Your ref:
Our ref: 21/01321/F
Please ask for: Mrs Joanne Rahman
Direct dial: 01553 616233
Direct fax: 01553 616652
E-mail: borough.planning@west-norfolk.gov.uk

Details: **Erection of the new shed and greenhouse at The Parsonage Creake Road
Burnham Thorpe King's Lynn Norfolk**

I have received a planning application as detailed above but cannot process it until I receive some more information:

| | Drawing No. | 015 | Proposed Plans & Elevations | | |

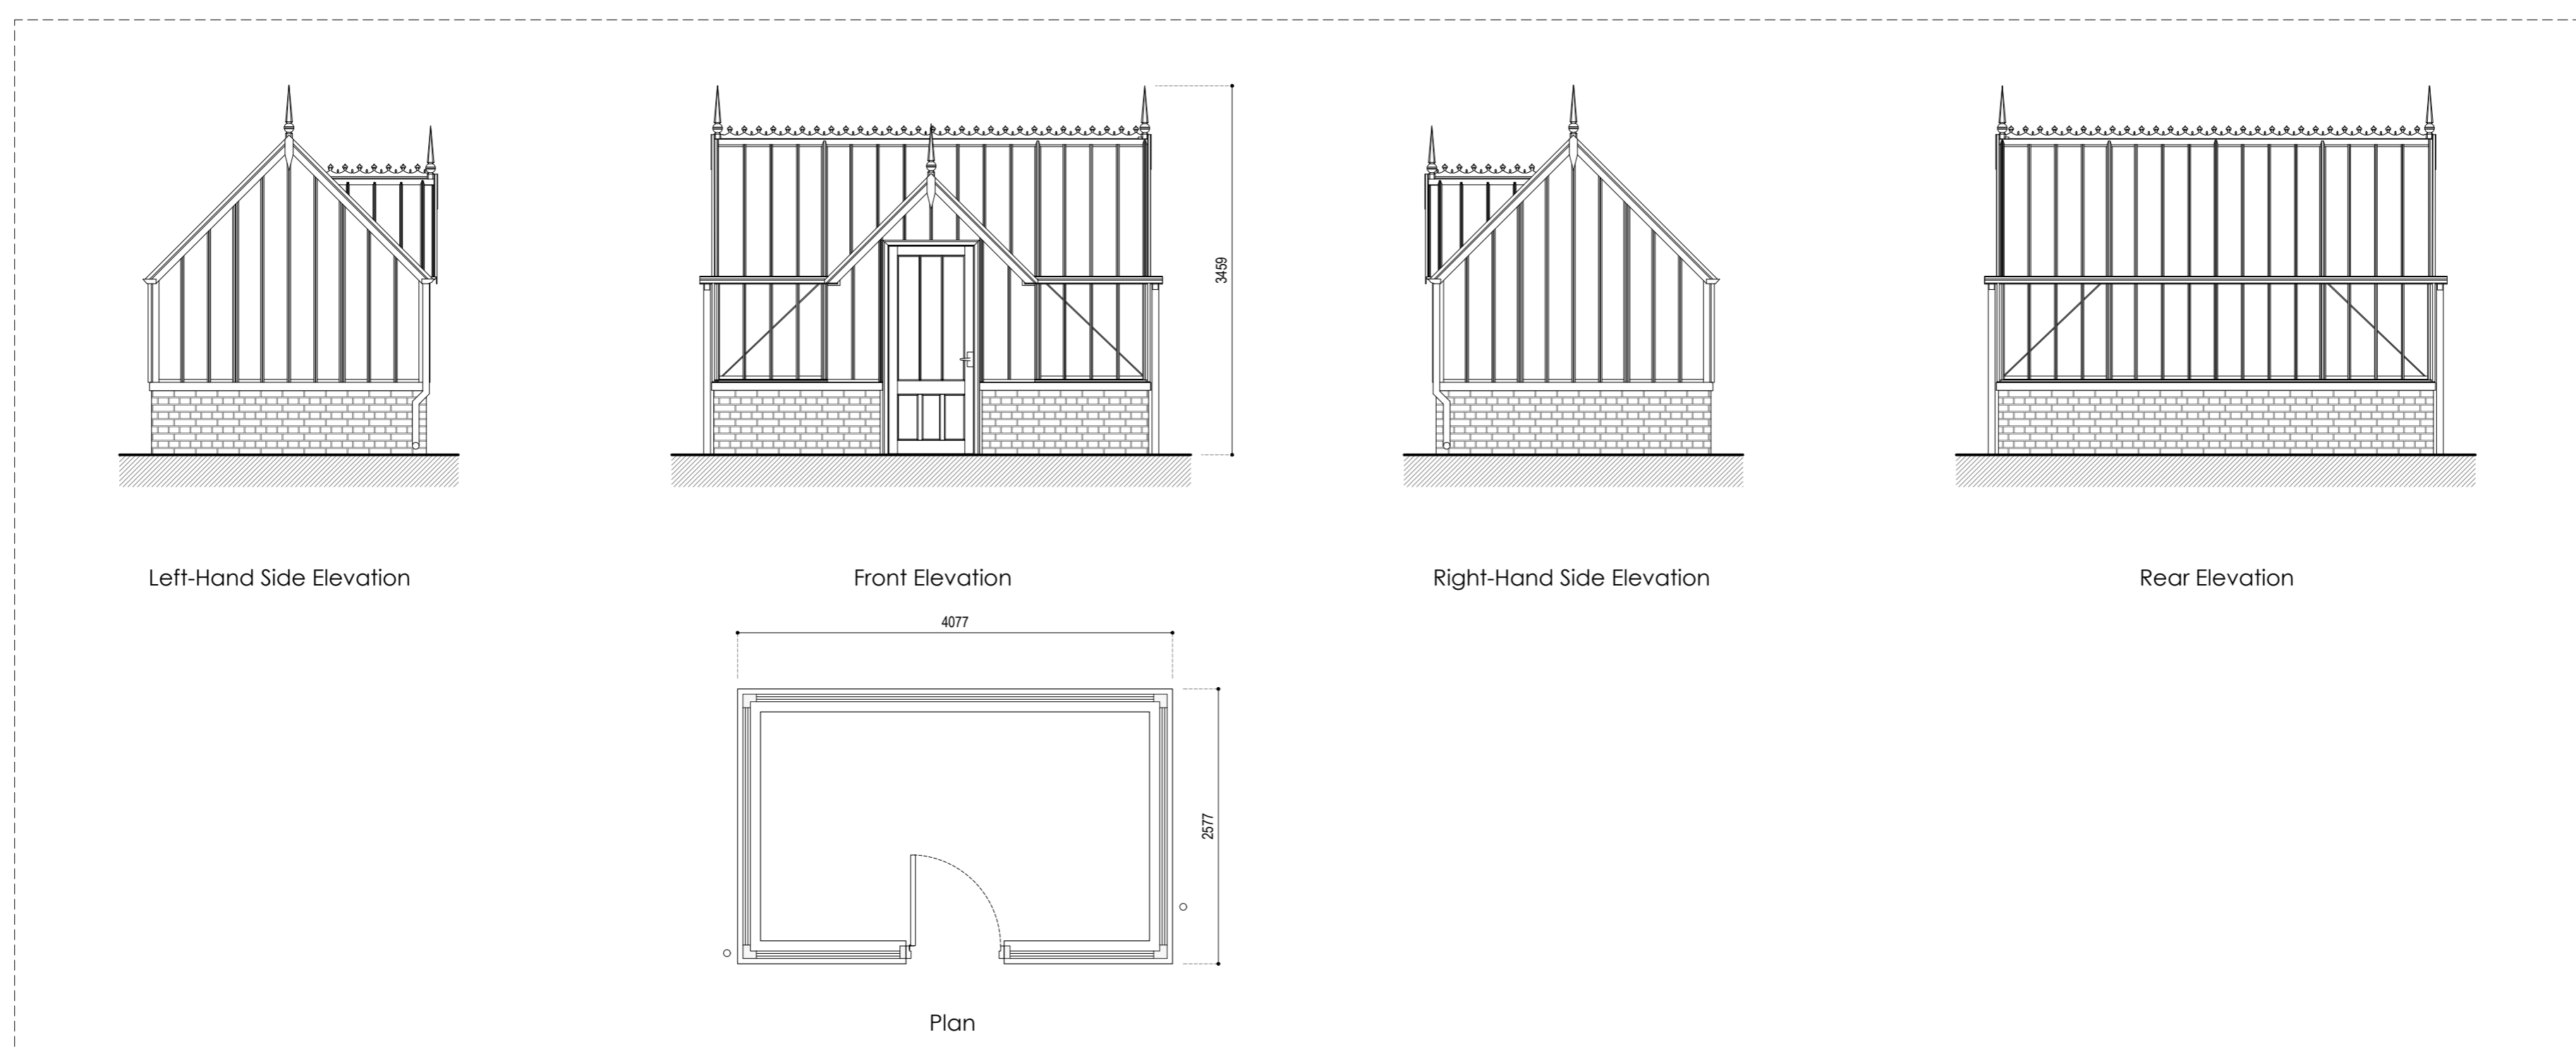
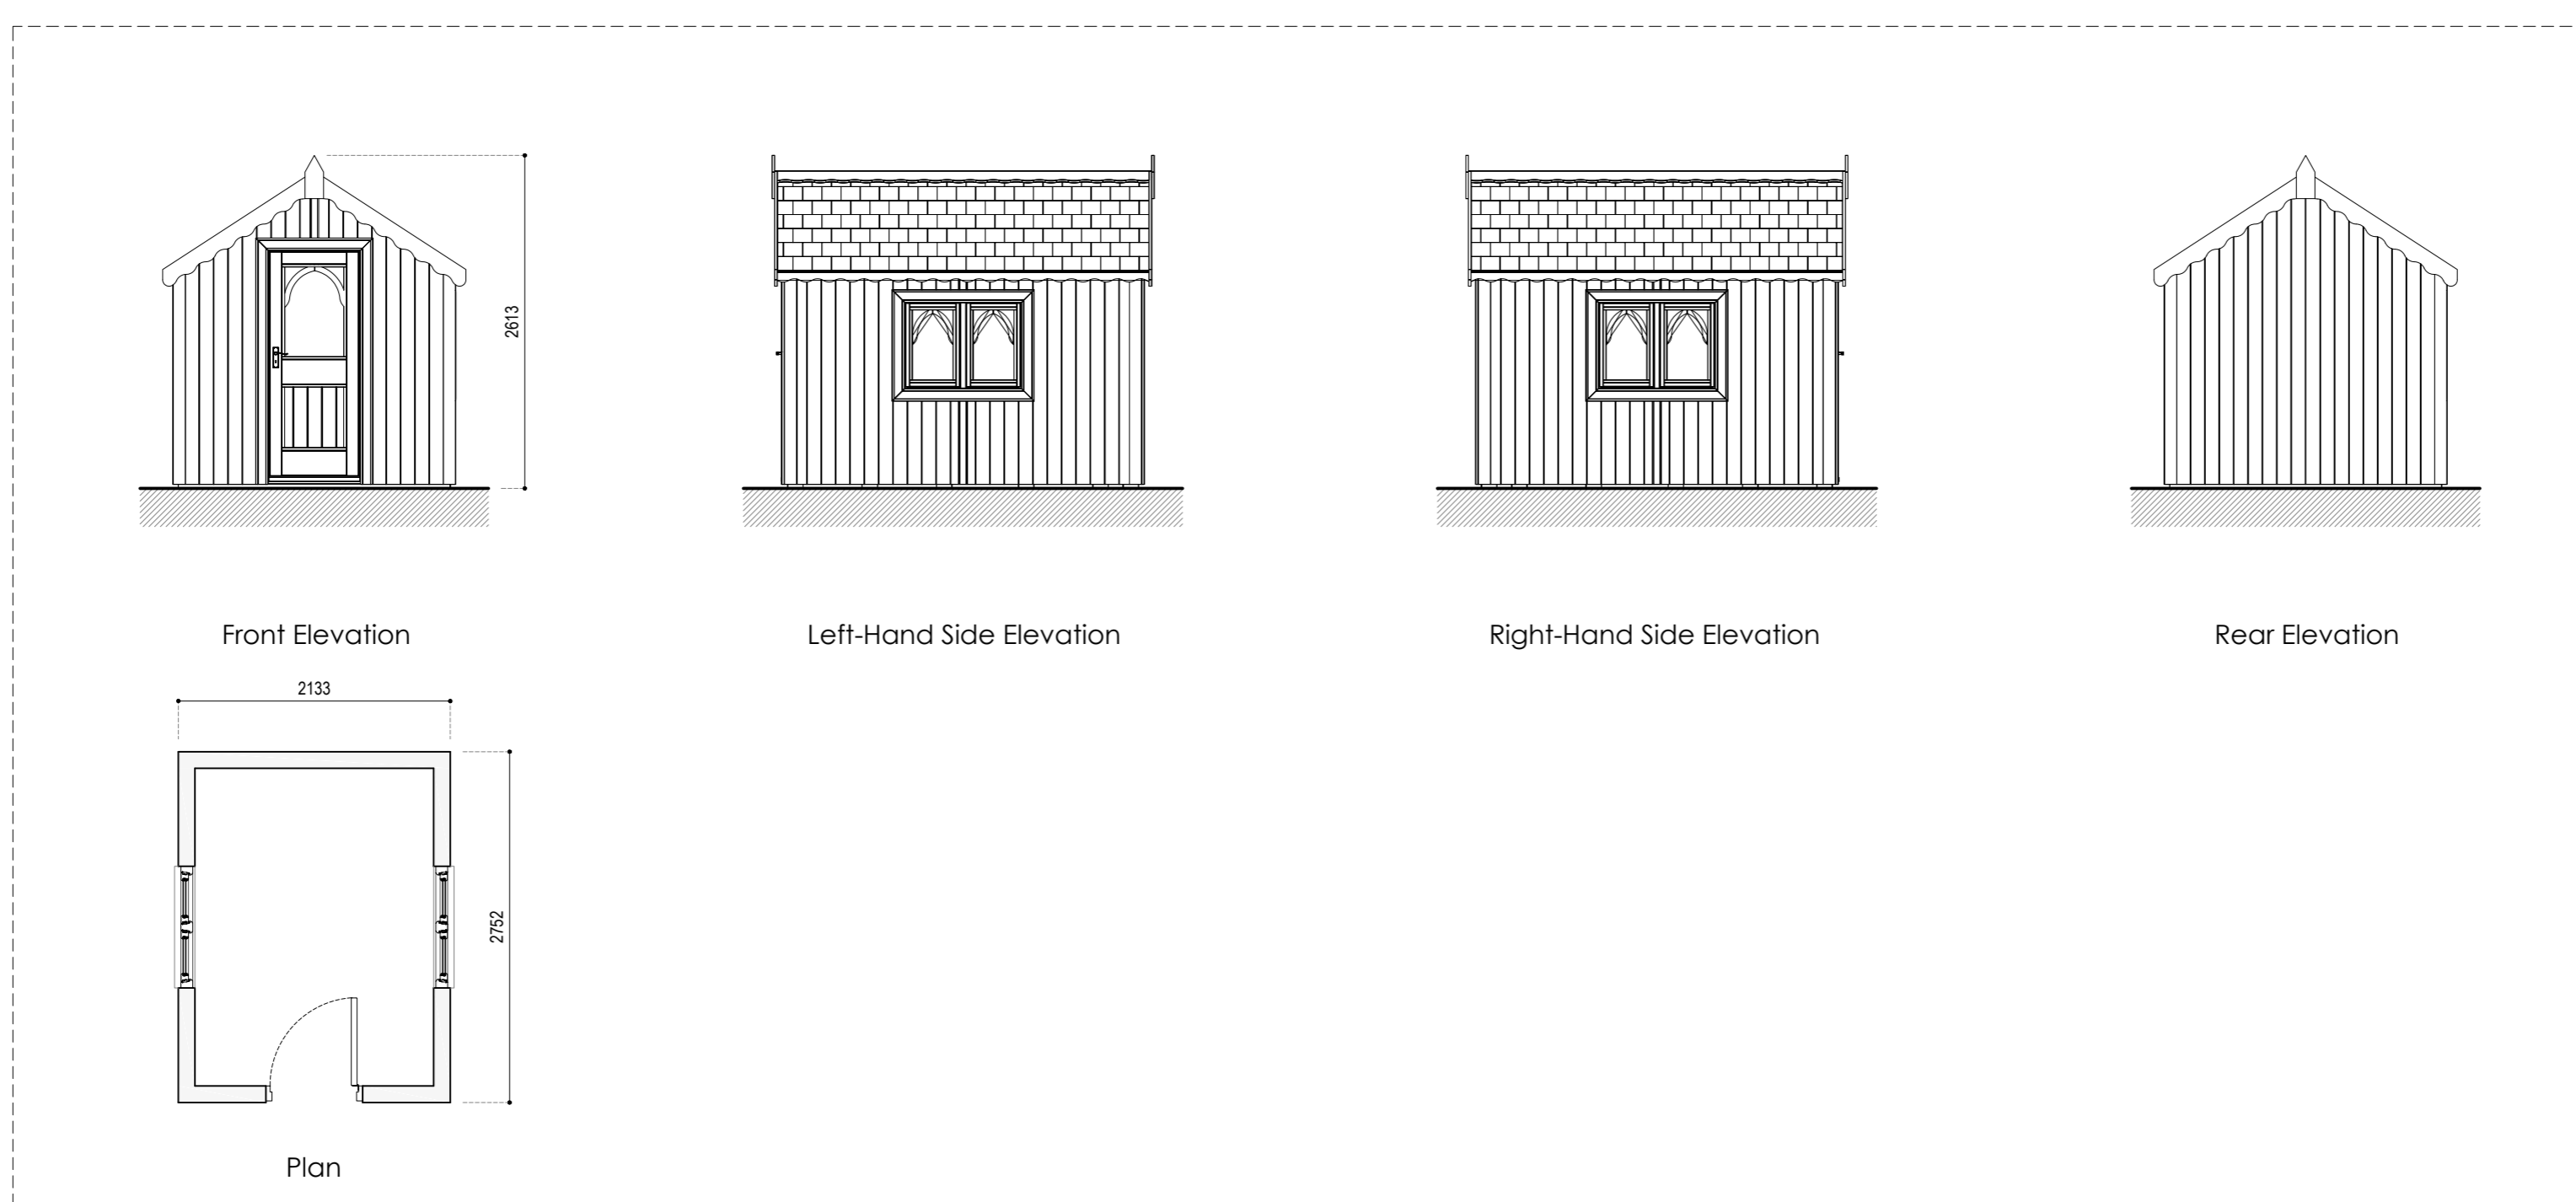
1. Please submit a proposed roof plan, this should be done to a scale of 1:50 or 1:100.
2. In accordance with the National Validation Checklist, which became mandatory on 6 May 2008, we will require information regarding site levels. If site levels are to change, please provide four copies of a site survey drawing, alternatively, if site levels are to remain unchanged, this can be annotated on the relevant plan or advised in writing.
3. The red line on your location/block plans should edge the curtilage of the dwelling. Please amend and resubmit your location and block plans.
